**June 5, 2013  
DRB Comments**

**PROJECT # 1009721**

**APPLICATION # 13-70569**

**RE: Lot 10-A-3, Alvarado Gardens Unit 2**

SKETCH PLAT

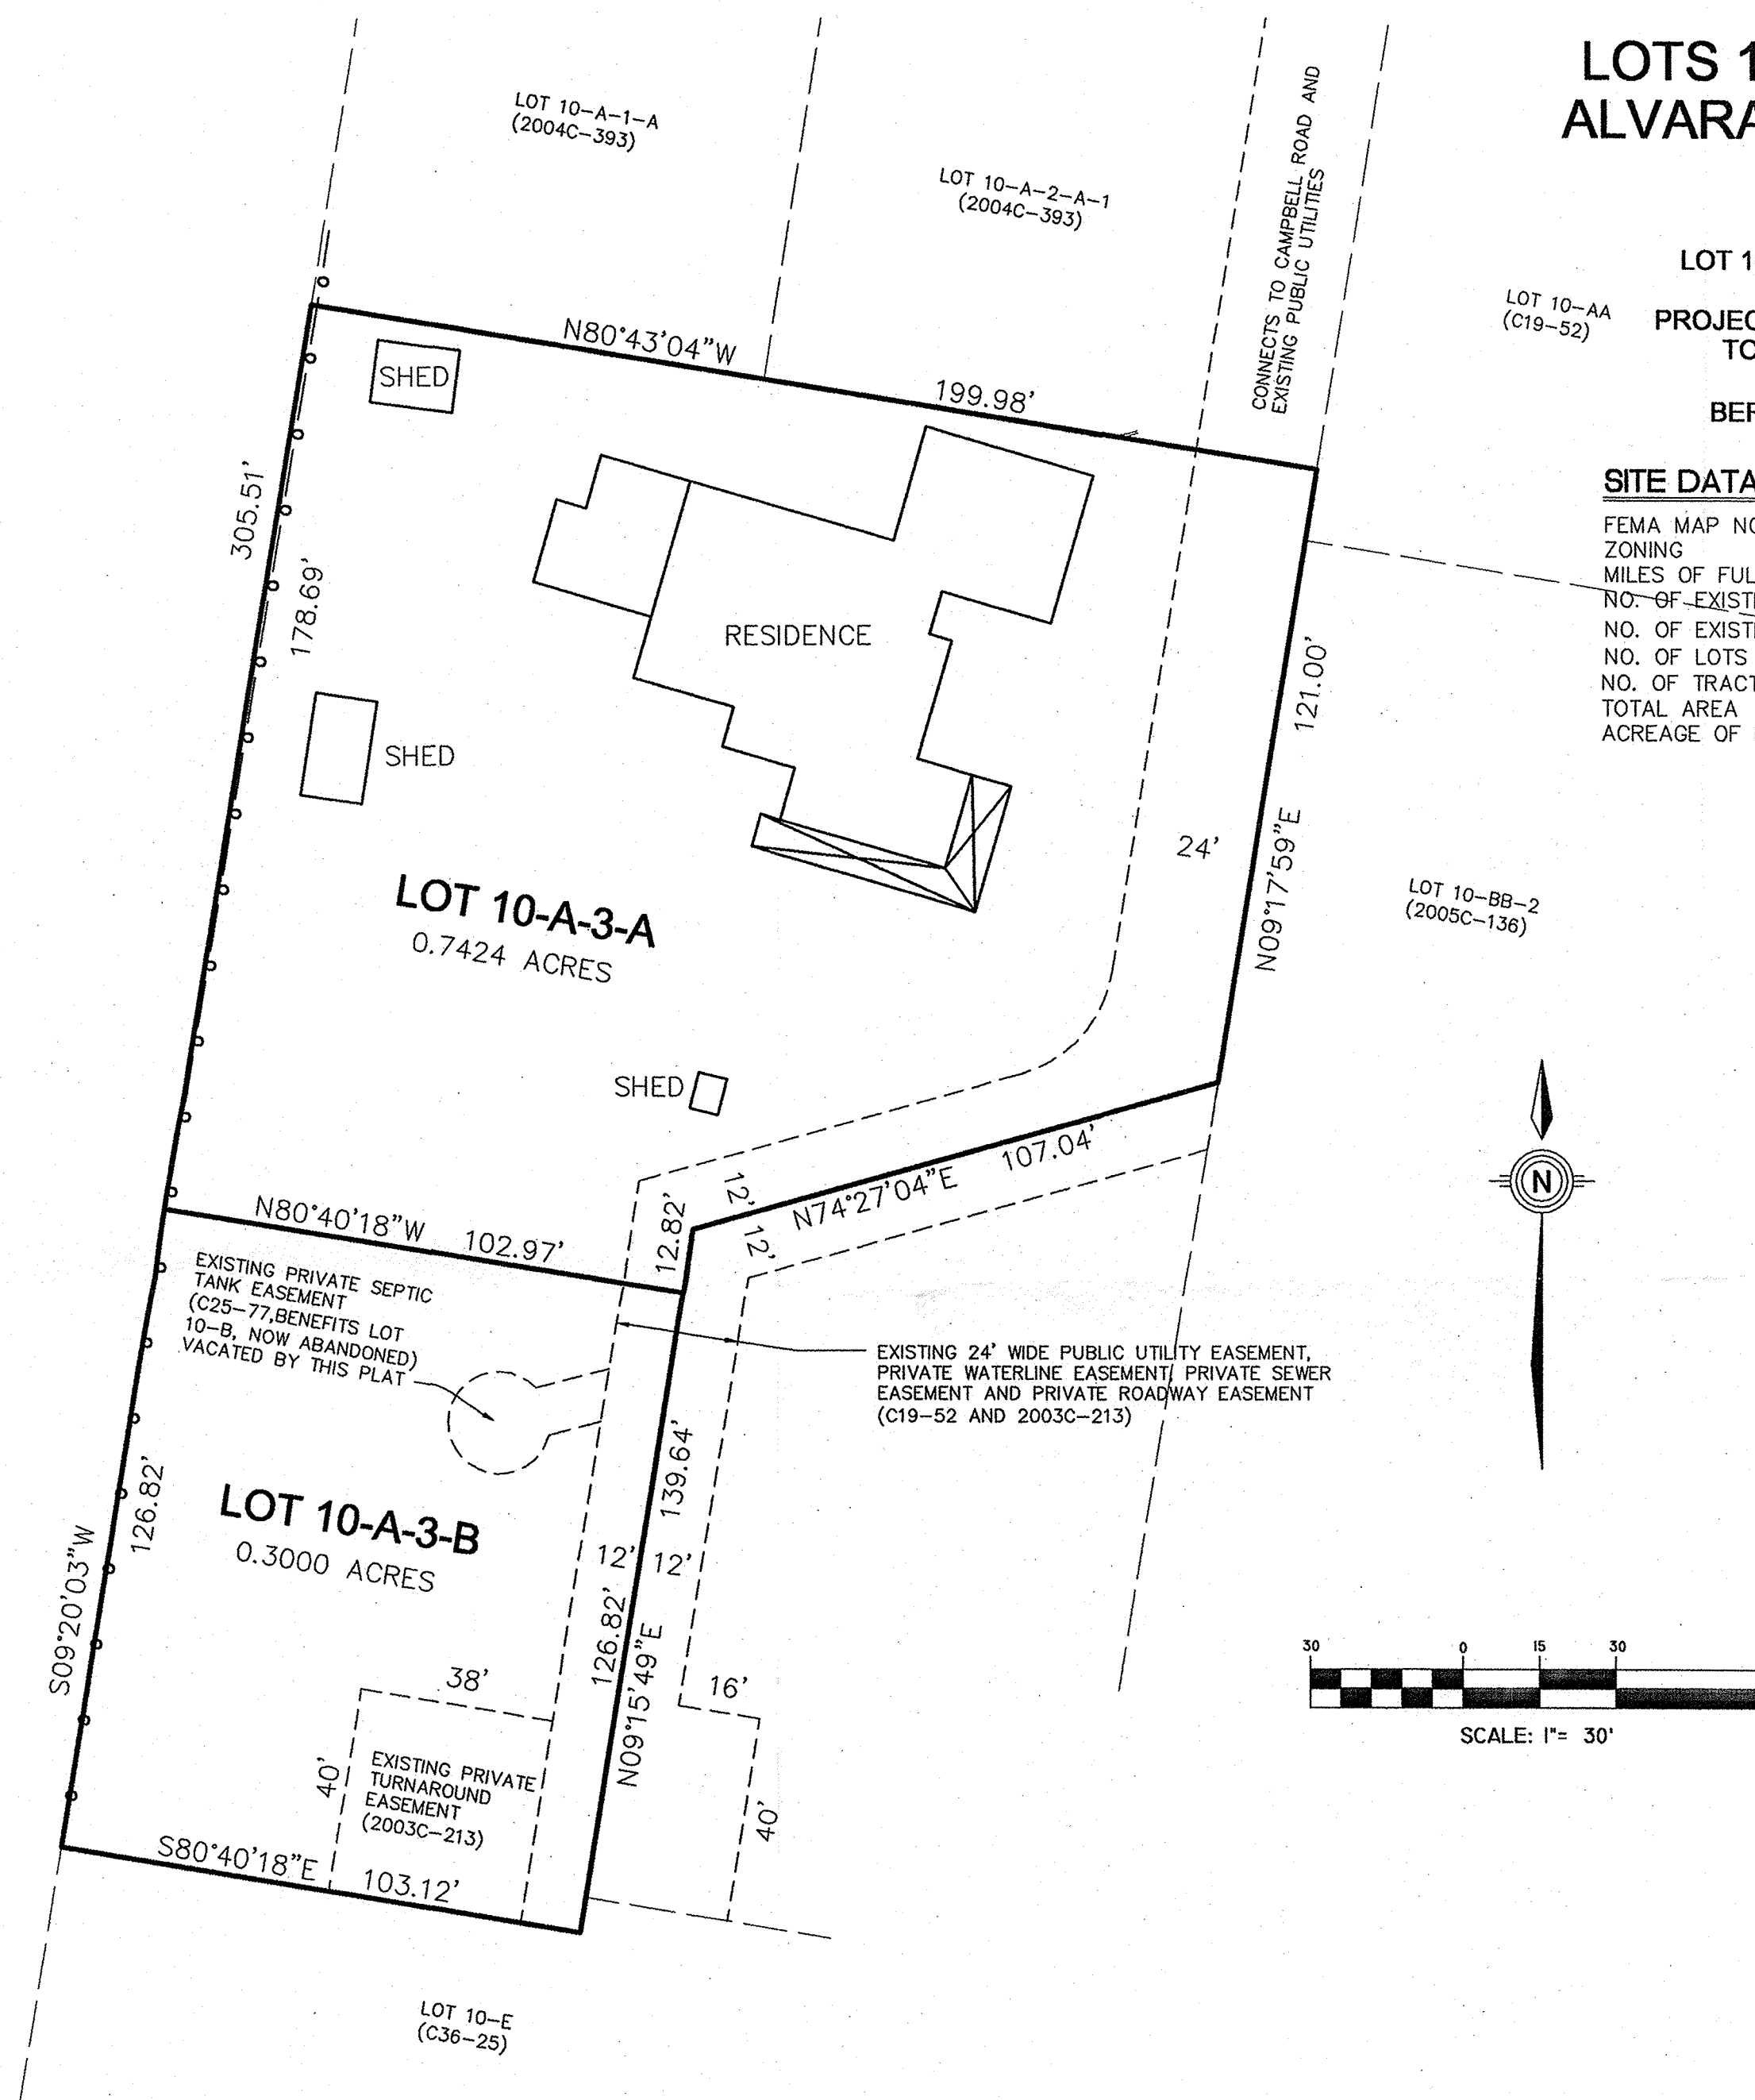
Please use City of Albuquerque Zone Atlas pages for City subdivisions.

Please provide a copy of the document(s) that created the access easement, to demonstrate maintenance and beneficiaries of the easement and any restrictions on additional users.

The easement does not meet the minimum requirements of the DPM; additional easement width, gravel pavement width and a sidewalk (all the way out to Campbell Road) may be required – refer to comments from Transportation Development.
